OFFICIAL NOTIFICATION OF DECISION

Project# PR-2020-004757
Application#
SI-2021-00307 SITE PLAN – DRB

For all or a portion of: **TRACT C48 AND C49,**
TOWN OF ATRISCO GRANT, zoned NR-BP,
located on **VOLCANO RD between CENTRAL**
AVE and BRISTOL ST containing
approximately 9.59 acre(s). (K-9)

RV STORAGE - ALBUQUERQUE
ALBUQUERQUE, NEW MEXICO
SITE PLAN
SITE PLAN

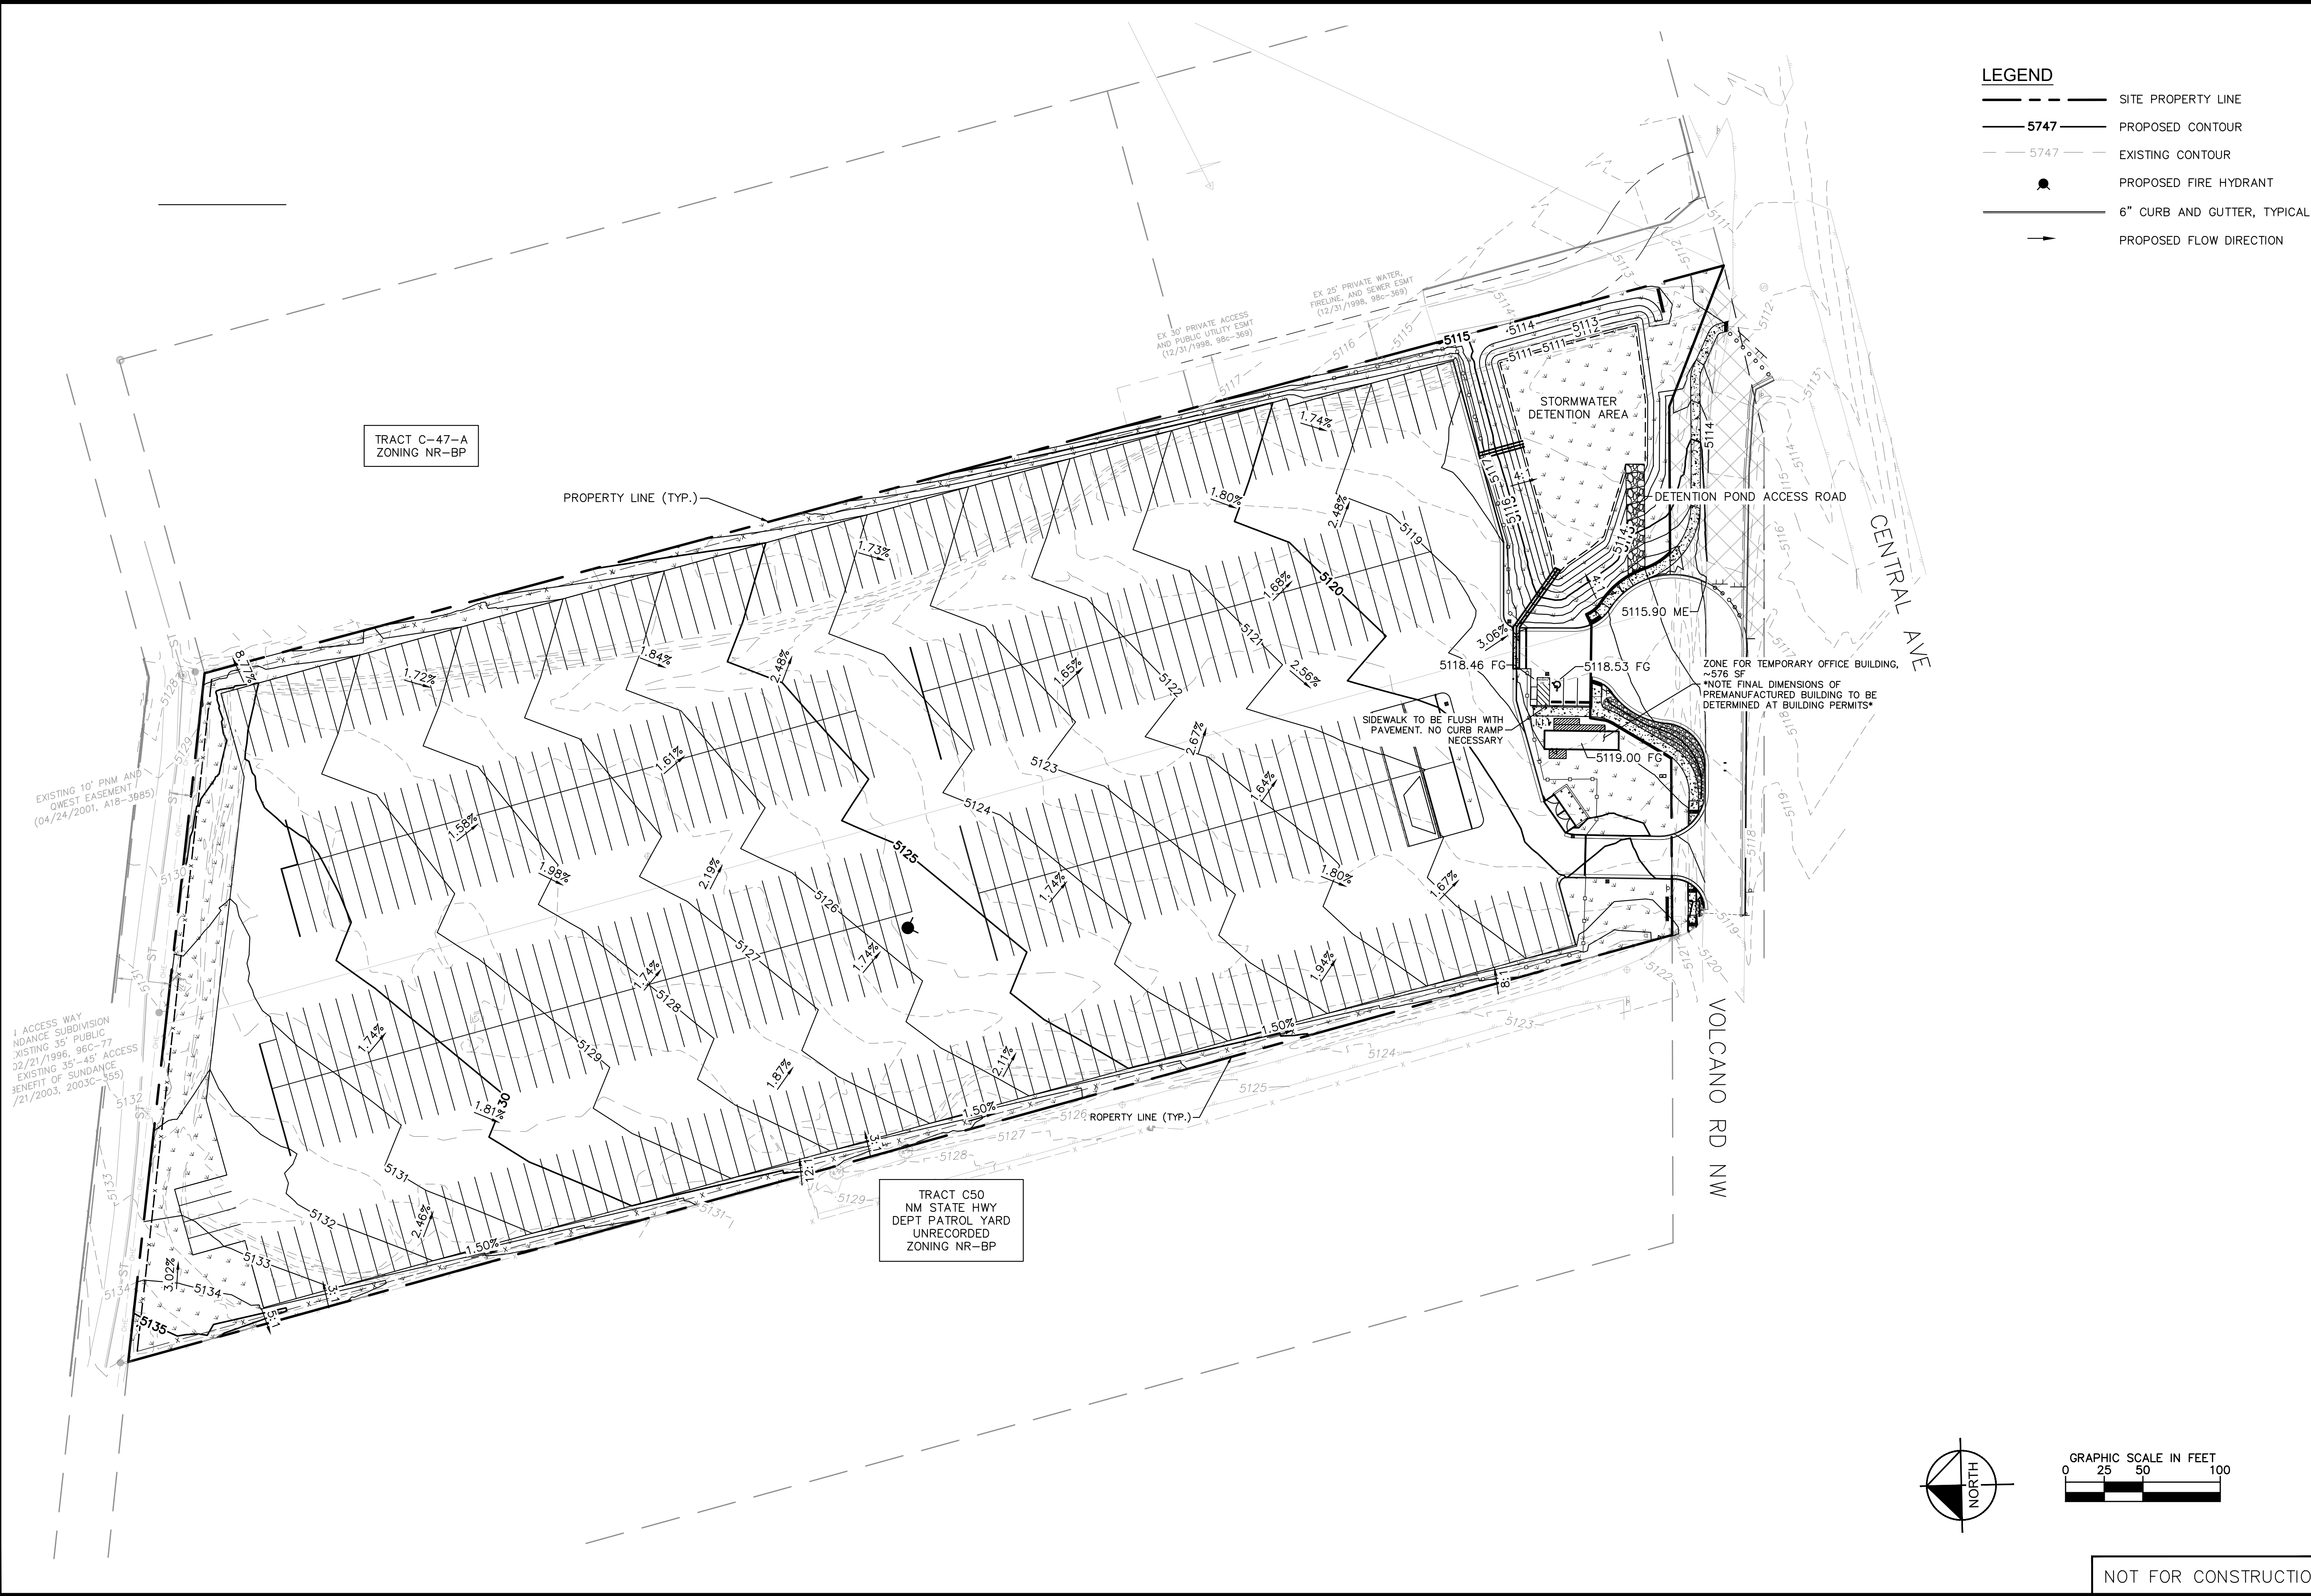
1. This Site Plan is valid 7 years from DRB approval (5/5/2021). An extension may be requested prior to the expiration date.
2. Final sign off is delegated to Transportation for correct reference for ramp details on Volcano Road with a note that these will be handled through work order, to adjust the project boundary line ensuring all public sidewalk on Volcano Road is within public right-of-way, and to specify that the sidewalk is flush with asphalt along front of the building to ensure ADA requirements.
